Our Ref: LU/209/19/HH
Your Ref:

Town & Country Planning Act 1990 (as amended)
Town & Country Planning (Development Management Procedure) (England) Order 2015
Application for Planning Permission for Works or Extension to a Dwelling

Development Two storey side extension and front porch
Location 12 Griffin Crescent Littlehampton

SITE PLAN 1:500 @ A4

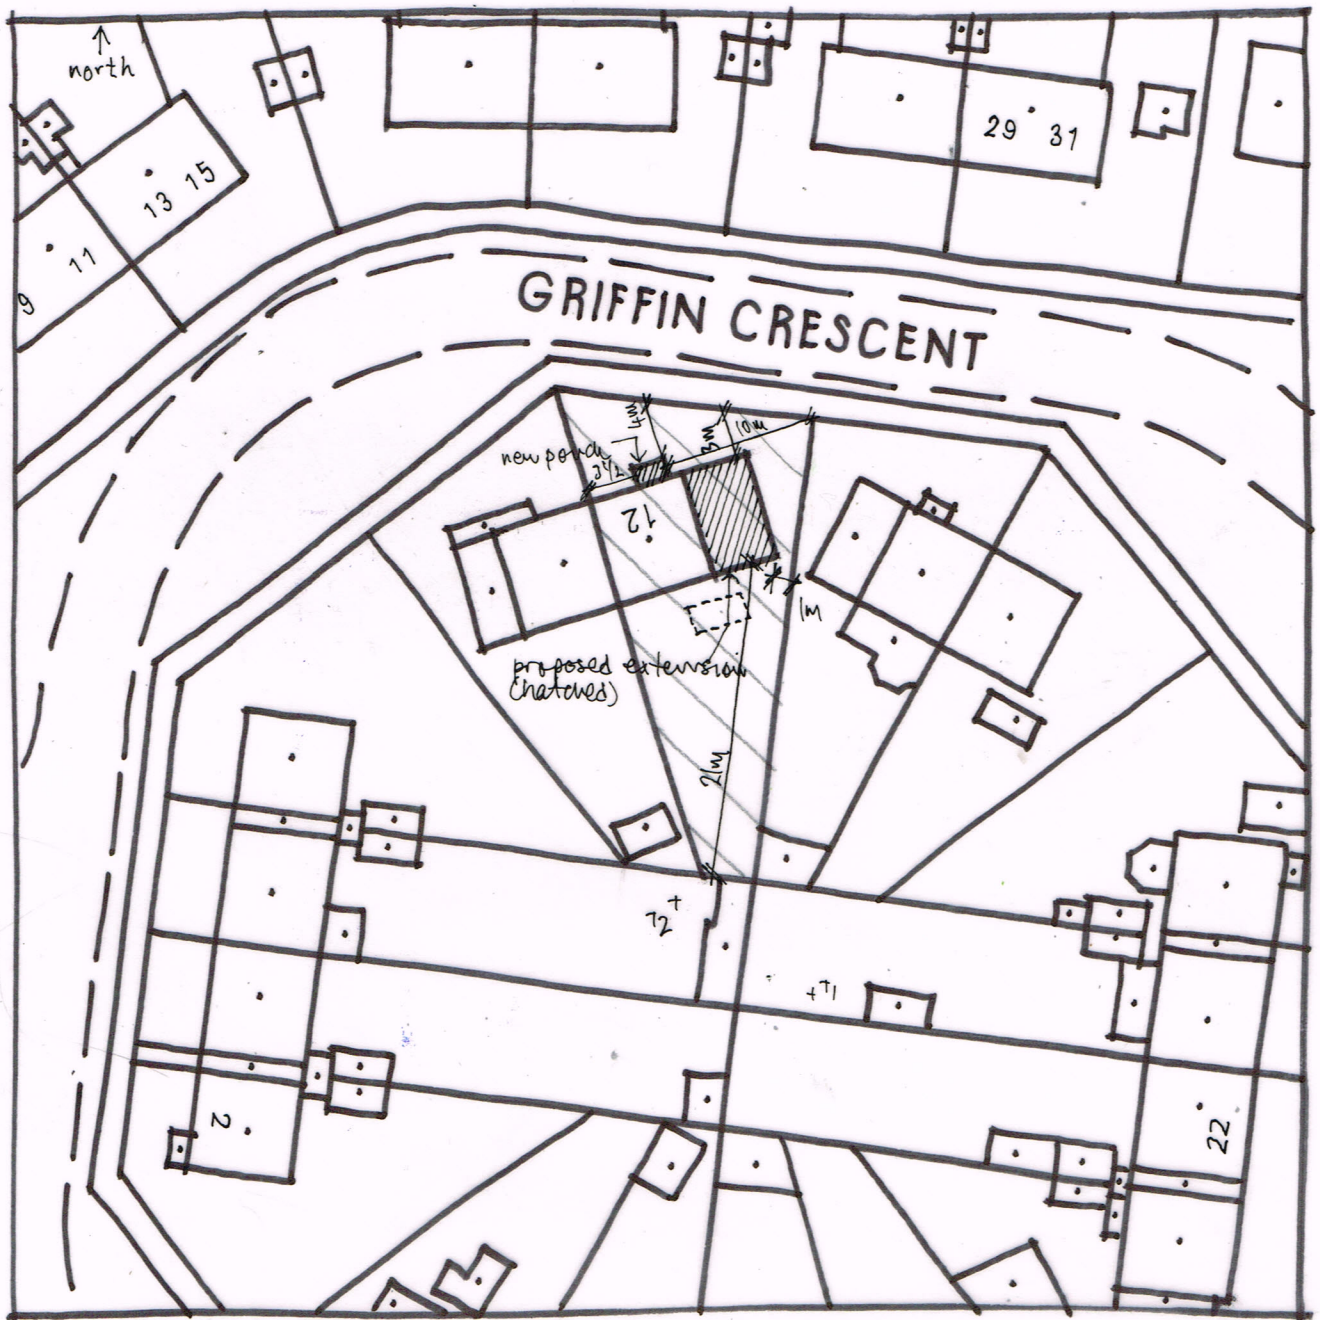
Block Plan

Please submit a dimension from the porch to the side boundary or confirm in an email what the distance is between the porch and side boundary.
